# CITY OF ALBUQUERQUE

June 29, 2018

**Re: Legacy NAA Apartment  
6115 Alameda Blvd NE  
Request Permanent C.O. – Bldgs. 11 and 16 - Accepted  
Engineer's Stamp Dated 4-22-16 (C18D073B)  
Certification dated: 5-24-18** 64

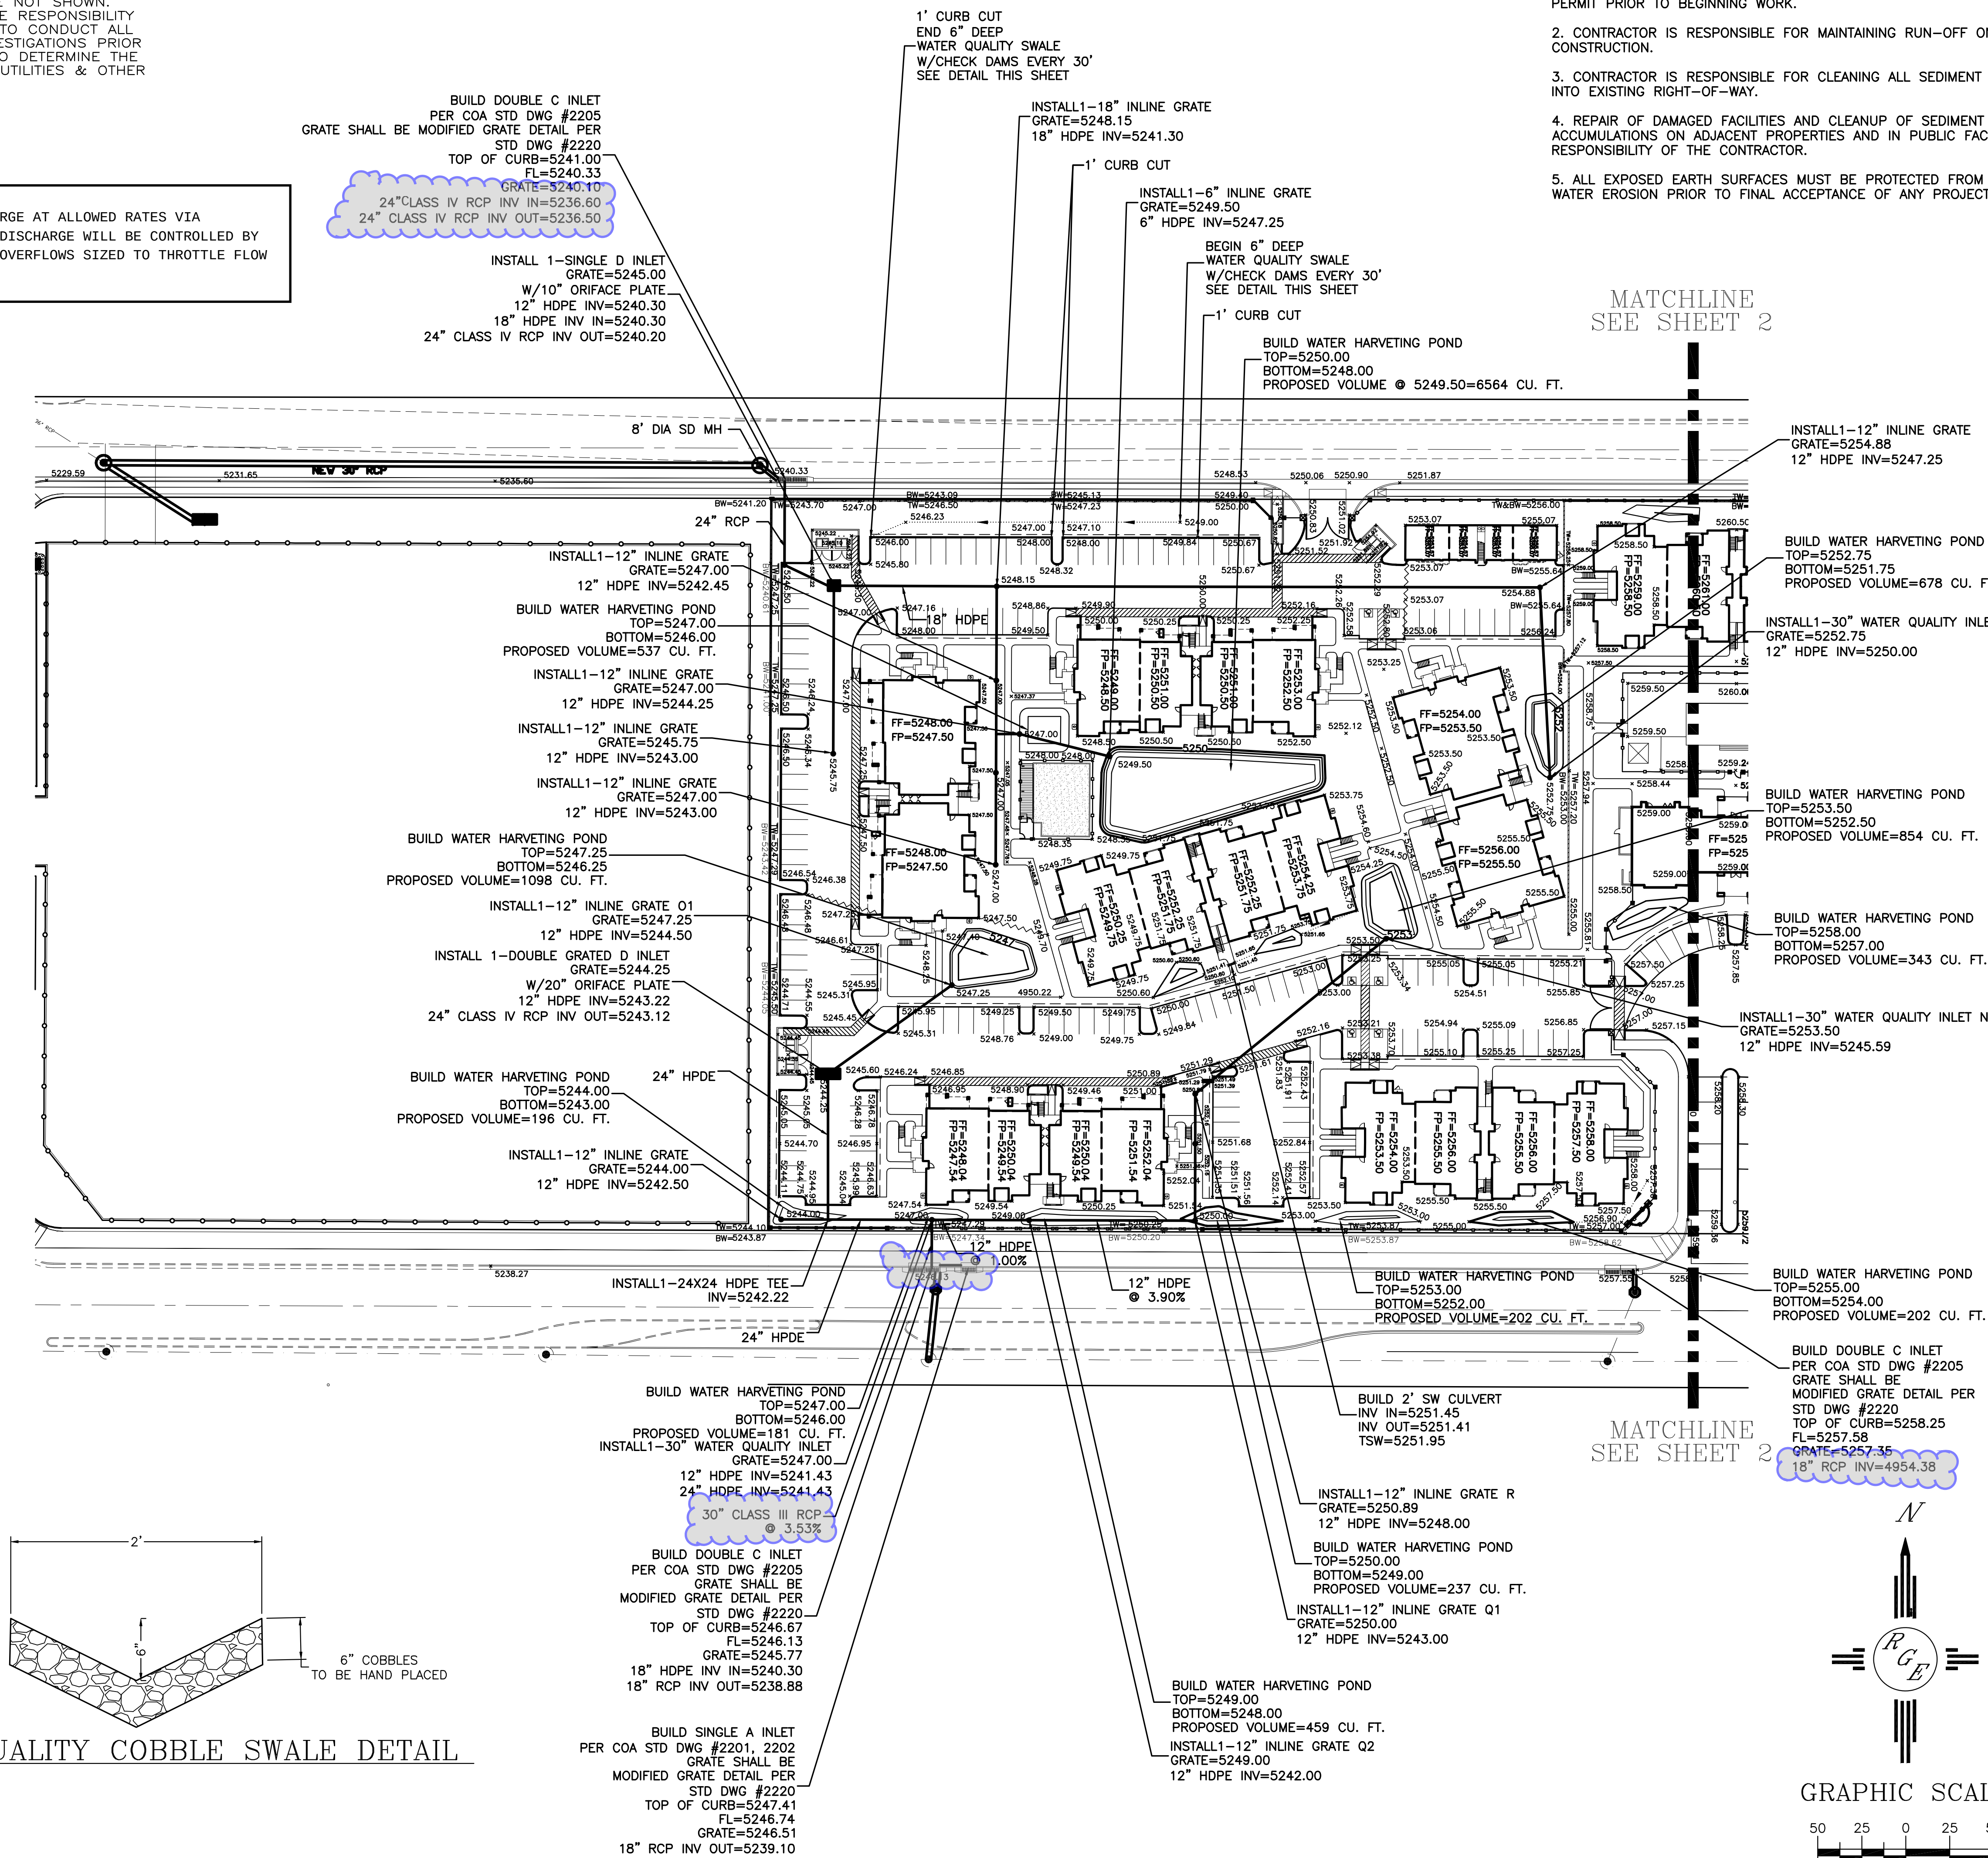
This letter serves as a "conditional approval" for building 11. At the NW corner of this building there is a transformer and other utilities in the location where the pond should be constructed. The pond volume will need to be provided at another location on site prior to final Certificate of Occupancy of the project.
